Our ref: KT/2024/132122/01-L01
Your ref: EN010135
Date: 10 December 2024

Stonestreet Green Solar Park Development Consent Order Application

Please find below our Written Representation on behalf of the Environment Agency in relation to the application for a Development Consent Order (DCO) for the Stonestreet Green Solar Park made by EPL 001 Limited (the applicant).

STONESTREET GREEN SOLAR  
ENVIRONMENTAL STATEMENT  
DELINEATION OF FLOOD ZONES  
3A AND 3B

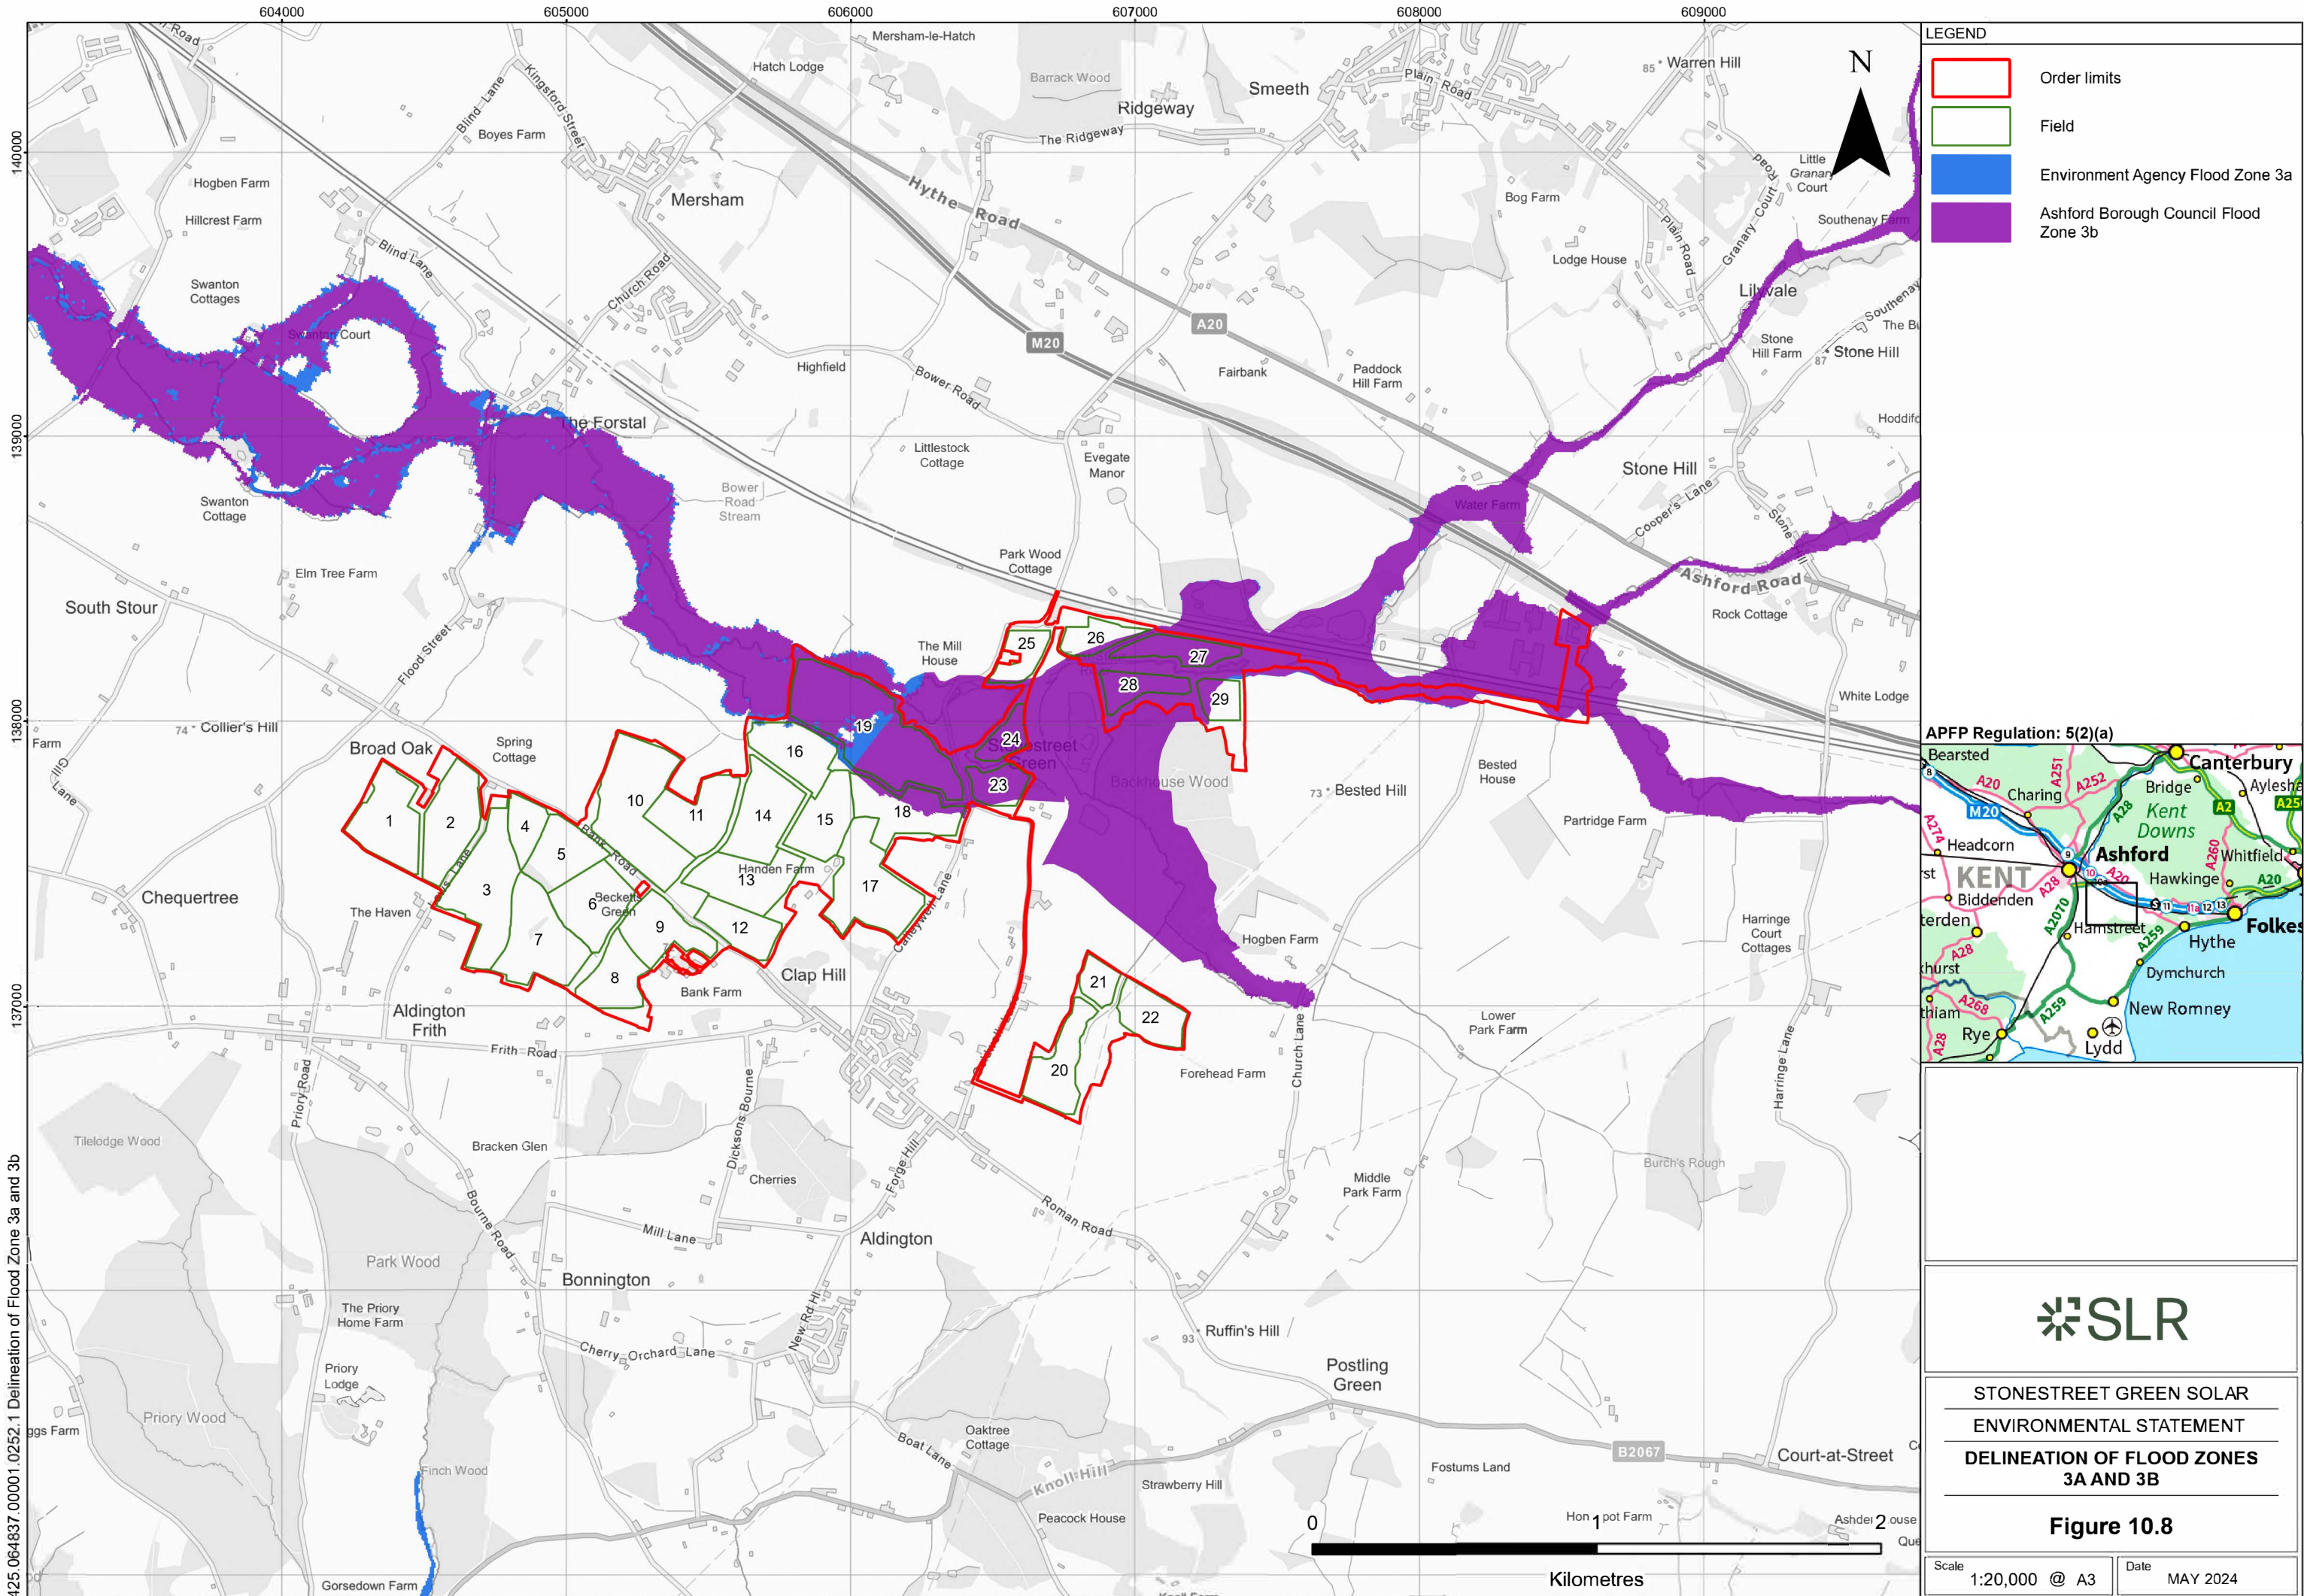
- 2.21. Situation: The 8m standoff provided in the Aldington Flood Storage Area Risk Assessment (AFSARA) does not satisfy the standoff document we previously shared (see Appendix A in this letter). ([APP-097](#) – *Doc 5.4 Environmental Statement Appendix 10.4: Aldington Flood Storage Area Risk Assessment*)
- 2.22. Impact: We may be unable to maintain our owned assets resulting in an increase in flood risk.
- 2.23. Solution: Works should remain outside of the standoff area previously provided to the applicant. The Aldington Flood Storage Area Risk Assessment shall be amended to reflect this standoff area (see Appendix A).
